Engineers Comments Regarding Surface Water Drainage

Application Reference:	CM/18/25/DOC	Reviewer Reference:	ADC/EXT12/GK
Planning Officer:	Jessica Riches	Date of Review:	06/08/2025
Site Name:	Land West of Church Lane & South of Horsemere Green Lane Climping		
Application Description:	Approval of details reserved by condition imposed under reference CM/1/17/OUT relating to condition number 9 - i. surface water drainage scheme and ii. a foul water drainage scheme and condition number 10 - i./ ii. watercourses and iii. rising main and foul sewer pipe.		
Assessment Number:	1 of 2

NoApplication Reference: CM/18/25/DOC Site Name: Land to the West of Church Lane and South of Horsemere Green Lane Climping	Initial Issue Date: Issue Date: 02/0102024 Reviewer Reference: ADC/EXT12/GK
--	--

Drawing file: CM_18_25_DOC / Climping Flood Flow Analysis.pdf

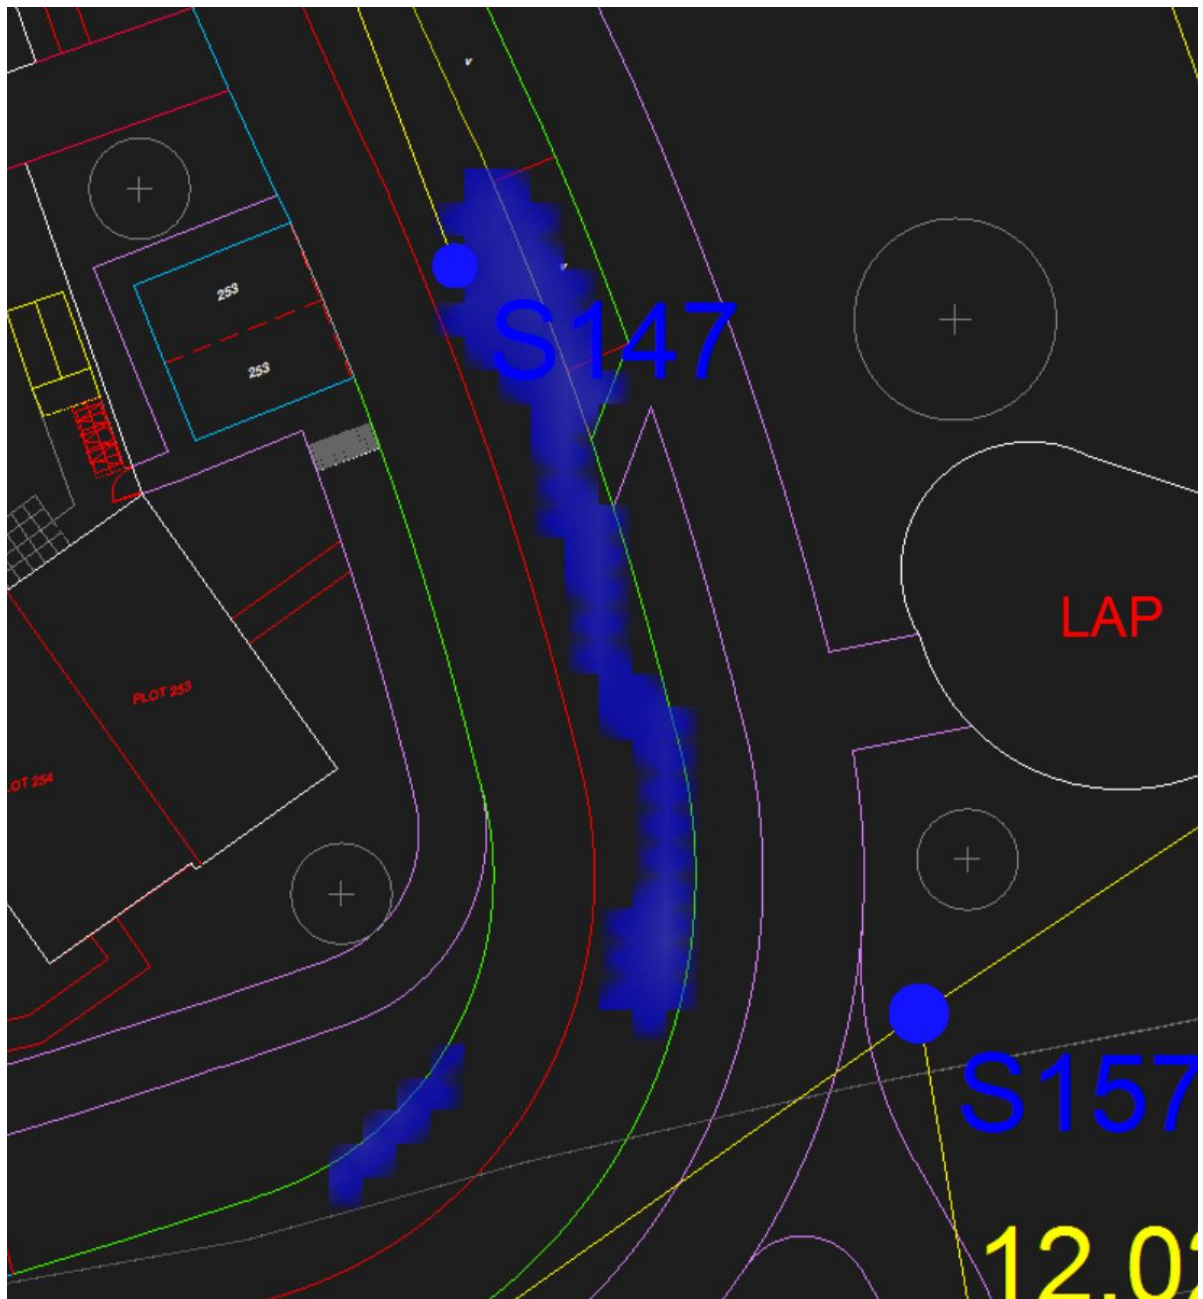
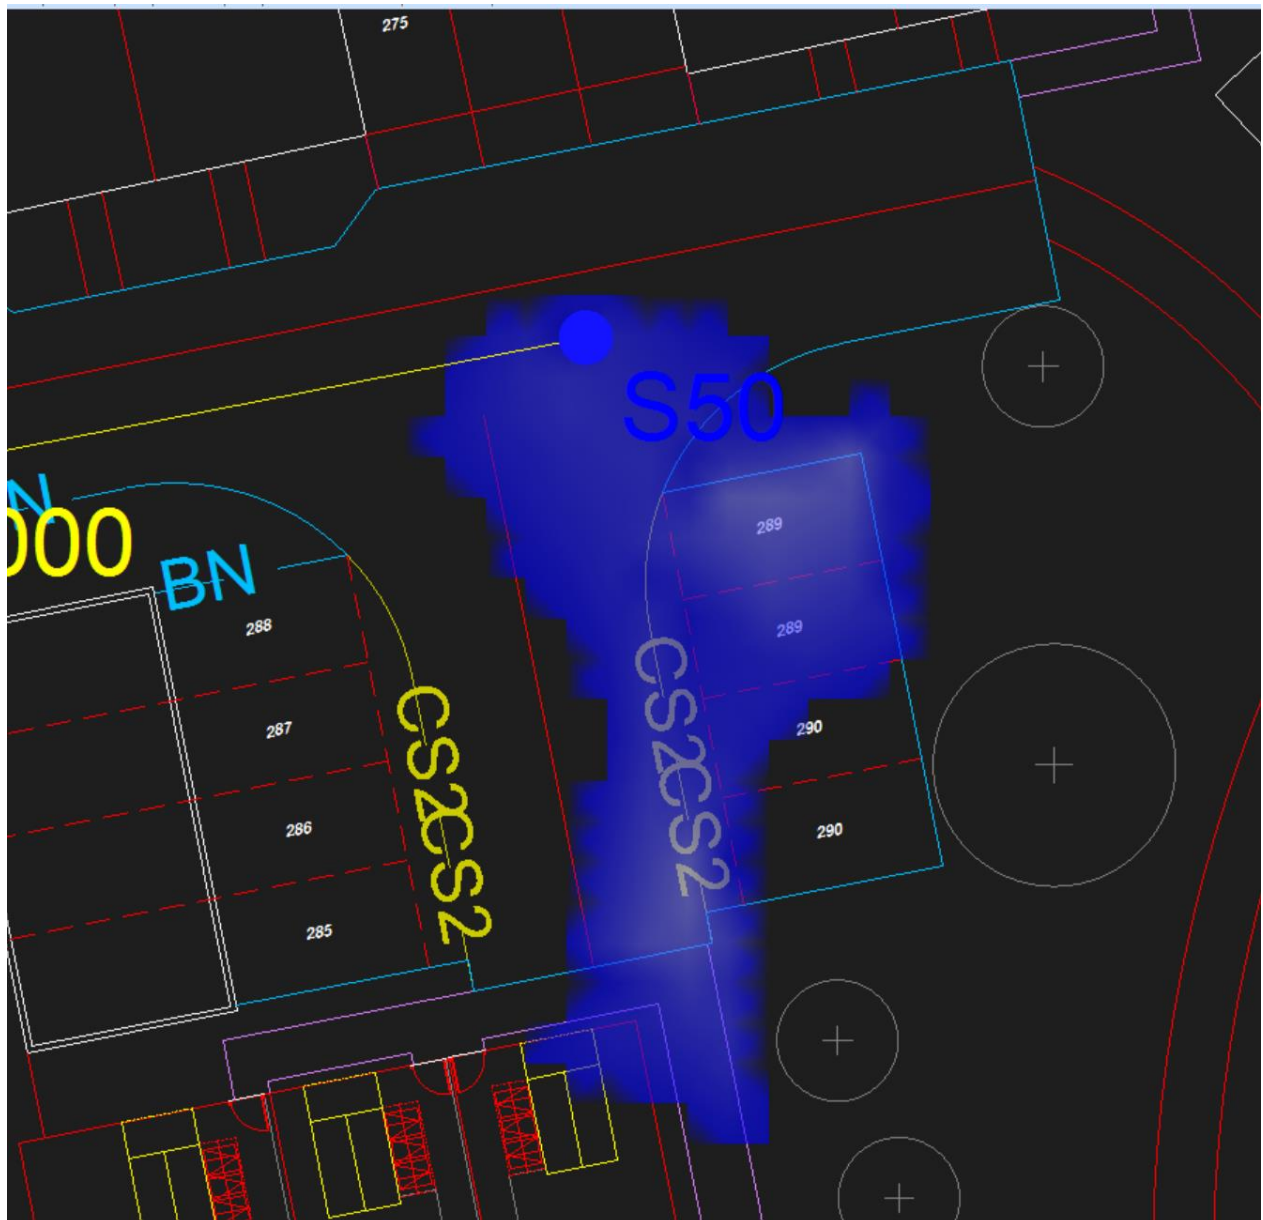
7.	The 1 in 100 year storm event clearly displays flooding, flooding should not occur where possible. In the instance of small flooding being unavoidable a plan displaying the extent of the flooding is to be provided including a flood management route.	No comments – refer to updated design.	Comment remains.	The calcs have been updated, small amounts of flooding are shown in the most extreme storm events modelled. A flood flows assessment has shown the minor flooding, exceedance flows will be contained within the highway and conveyed down the roads where it will enter the system further downstream via gullies.	Comment closed.
